Planning Officer: Zac Denton
Planning Application Ref: AW/84/18/T
Location: 33 Grange Court, Aldwick
Description of works: Re-pollard 1No. Golden Weeping Willow tree by 3metres, back to previous points
Reason Given: None provided
Comments on Application:

T1

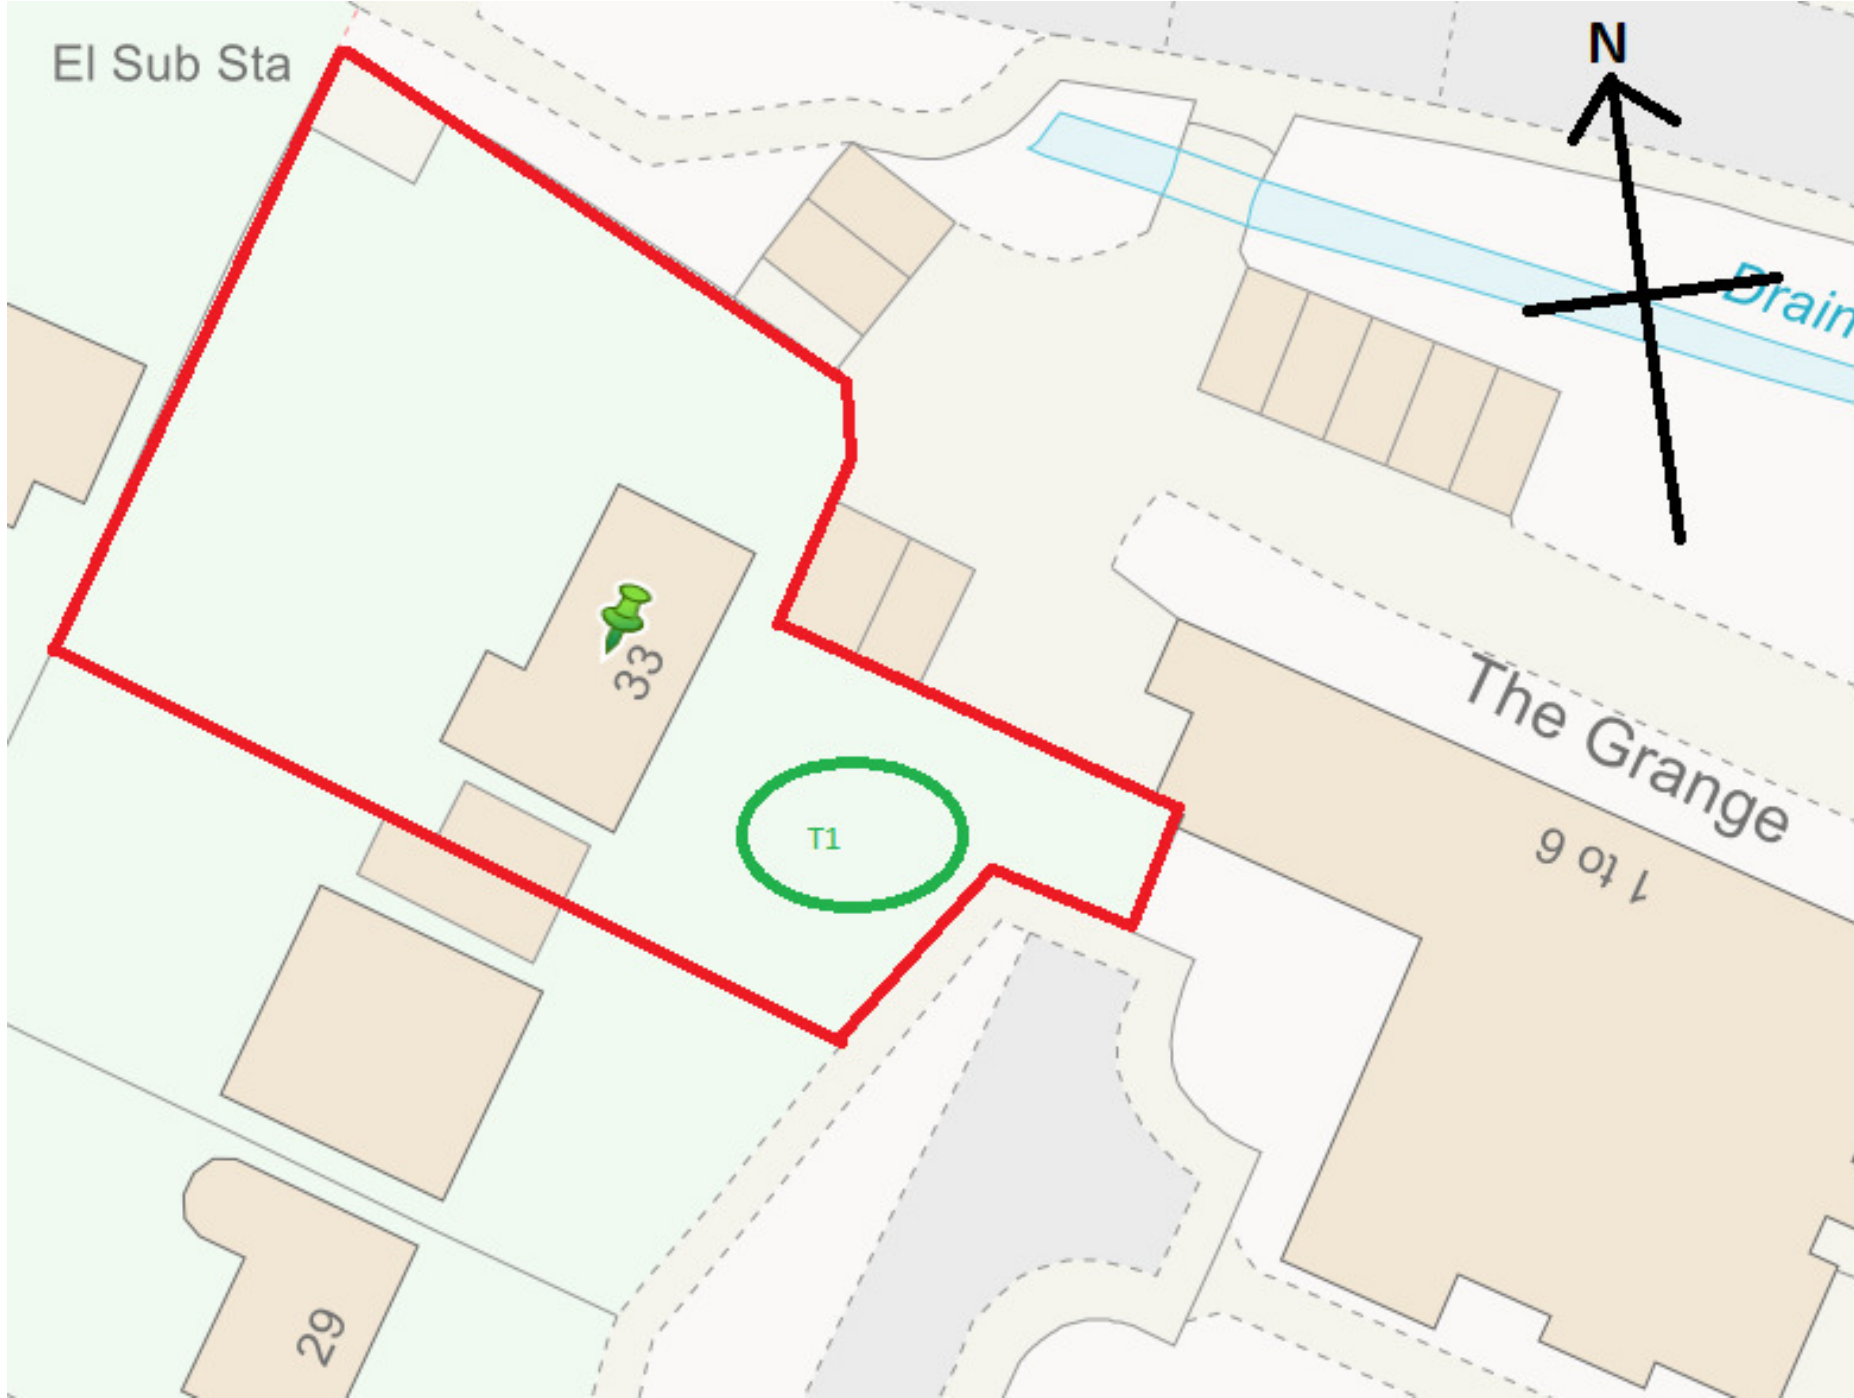
- This tree appears to be in good physiological condition. It has been subject to heavy crown reduction work previously and has responded with vigour; typical for a healthy example of its type and age.
- This tree is visible from surrounding properties and occupies a prominent central position to the front of this property.

- Repeat operations such as now being asked for by the applicant will be necessary throughout the remaining life-span of this tree, to achieve a reasonable degree of structural integrity appropriate for its location.
- If the work is undertaken to a good standard and at the right time; then repeat crown reduction is unlikely to have an adverse effect on its long-term vitality.

Condition - The removal of crown material which has developed since the last operation must be done sympathetically and with respect to established 'knuckles' so as not to extend beyond the point of origin.
